Recommendation Report for Planning Permission

REF NO: BR/233/19/PL

LOCATION: 77 Aldwick Road
Bognor Regis
PO21 2NW

PROPOSAL: Part change of use of ground floor & formation of a first floor rear extension to create 2 No self-contained studio flats with associated refuse/ recycling & cycle store (resubmission following BR/63/18/PL).

Drawing
PROPOSED FLOOR PLANS

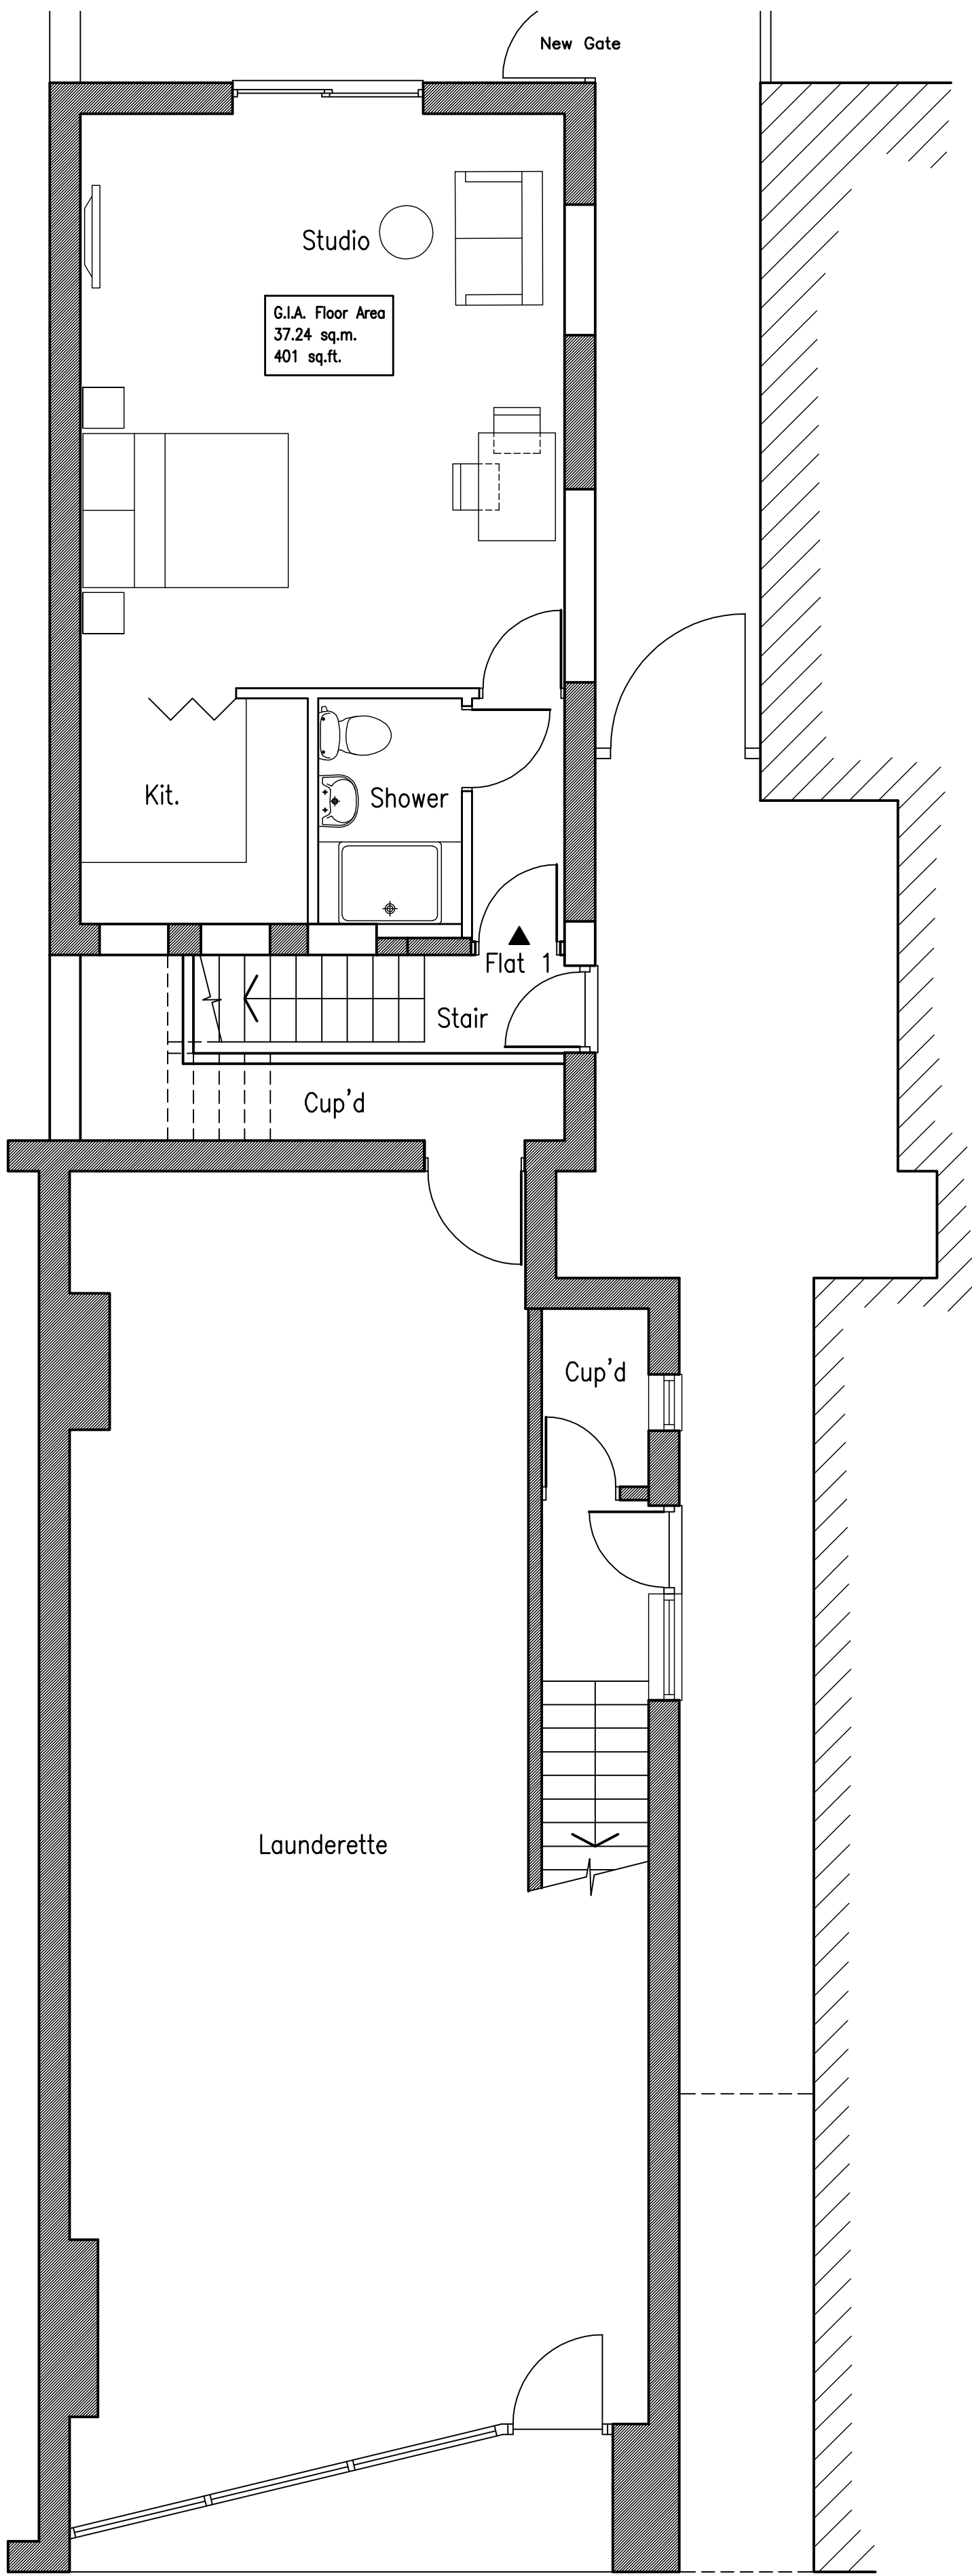
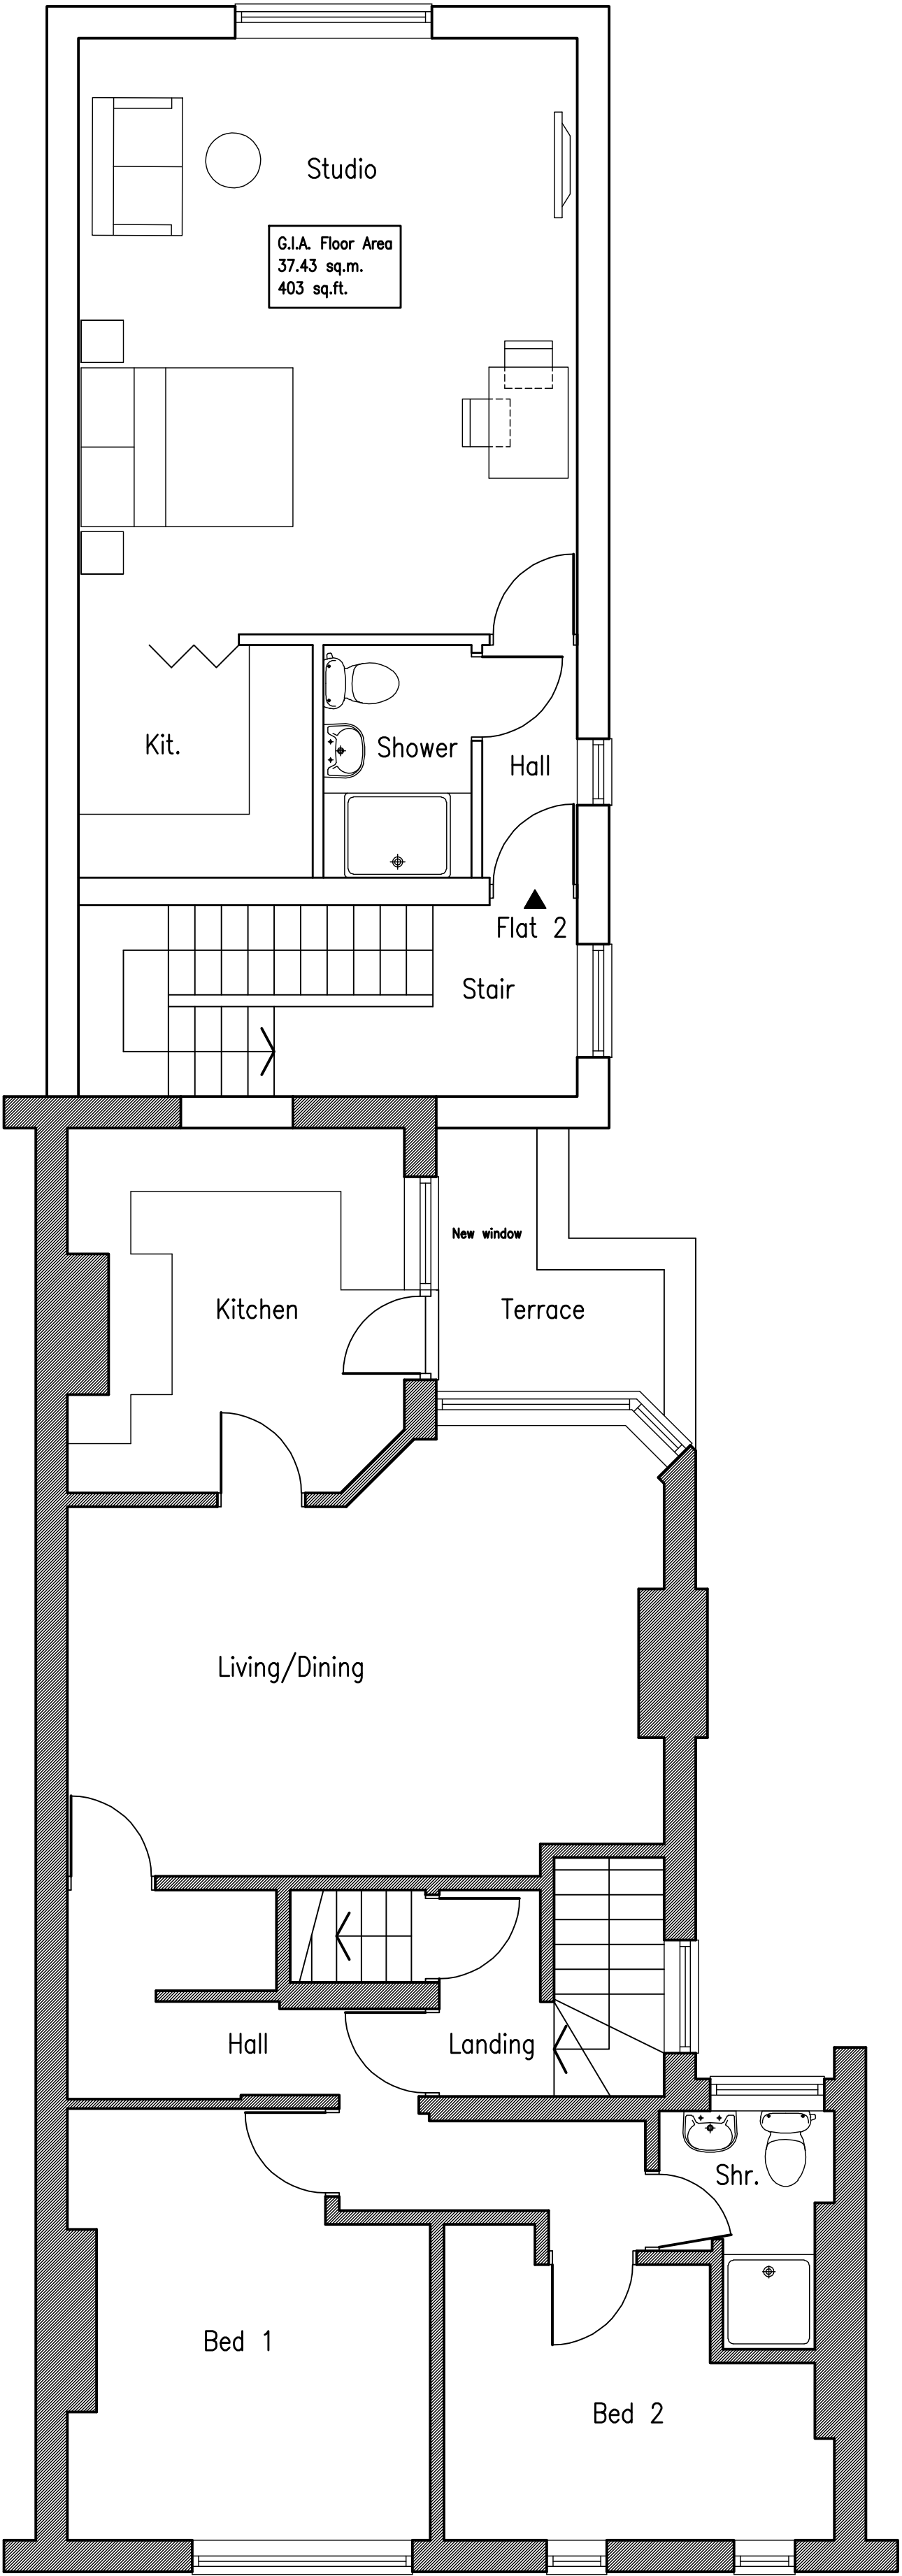
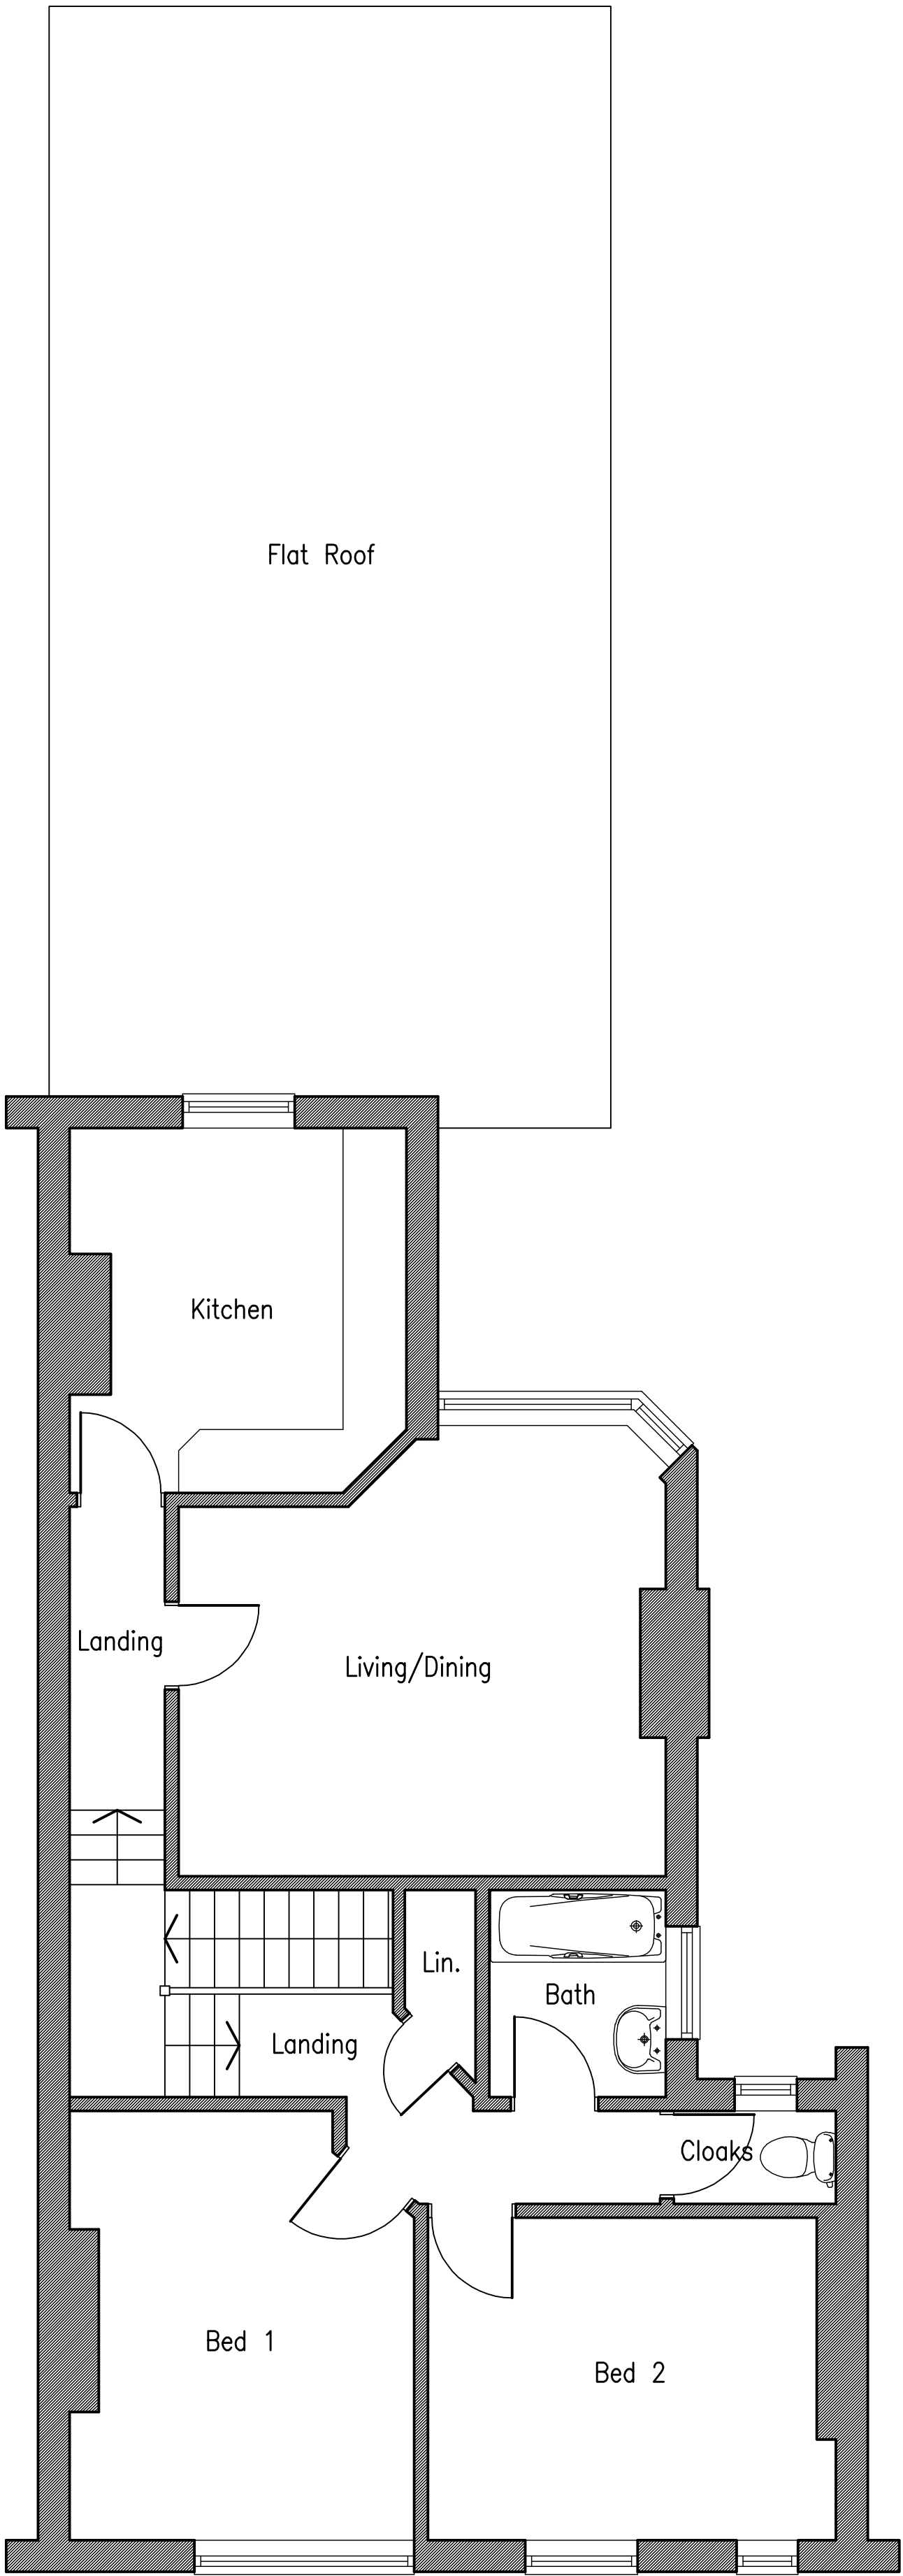
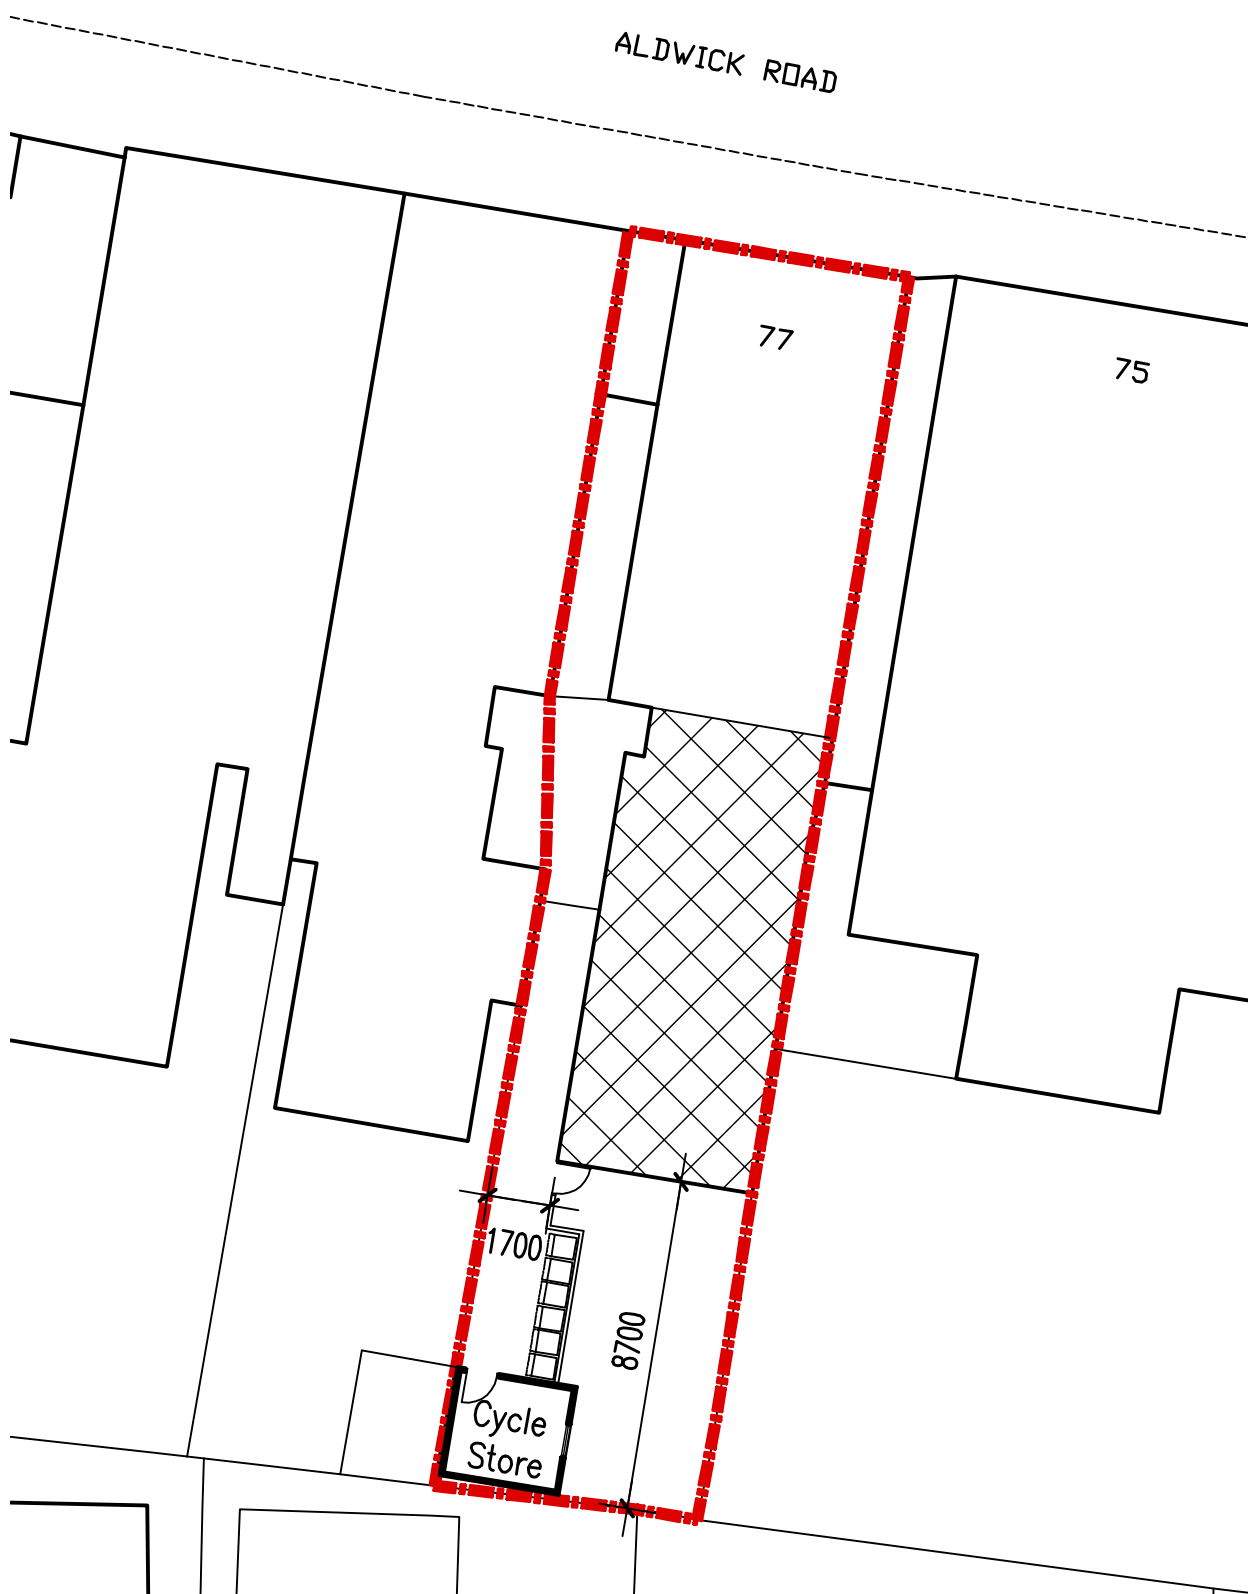
The first floor studio apartment would introduce development within 8.7m of the southern boundary of the site. The close proximity of the proposed first floor apartment would result in overlooking into the rear private amenity space of nos. 10 and 14/16 Stocker Road. This matter was raised within the refusal of planning permission BR/63/18/PL. Site sections were requested to better understand the nature of visibility, overlooking and interrelationship with the adjacent property to the south to allow a balanced judgement to be made regarding the nature and extent of harm. However, the applicant declined to provide a site section to assist the Council in their assessment in email correspondence dated 05 December 2019.

Bognor Regis Town Council raised this relationship as being problematic and the nature of the relationship remains the same as per application BR/63/18/PL. On this basis, the development would result in an undue in an unacceptable visibility of the rear private amenity space of nos. 14/16 Stocker Road which would result in an unacceptable level of private amenity to the occupants of nos. 14/16 Stocker Road.

- 2 The new first floor studio apartment window on the southern elevation of the building will look out towards the rear private amenity spaces of nos. 10 and 14/16 Stocker Road at a distance of around 8.8m. In the absence of requested sight line sections/diagrams the proposal will result in a loss of privacy to the adjacent amenity spaces of nos. 10 and 14/16 Stocker Close; contrary to Policies D DM1, D DM4 and QE SP1 of the Arun Local Plan and National Planning Policy Framework.
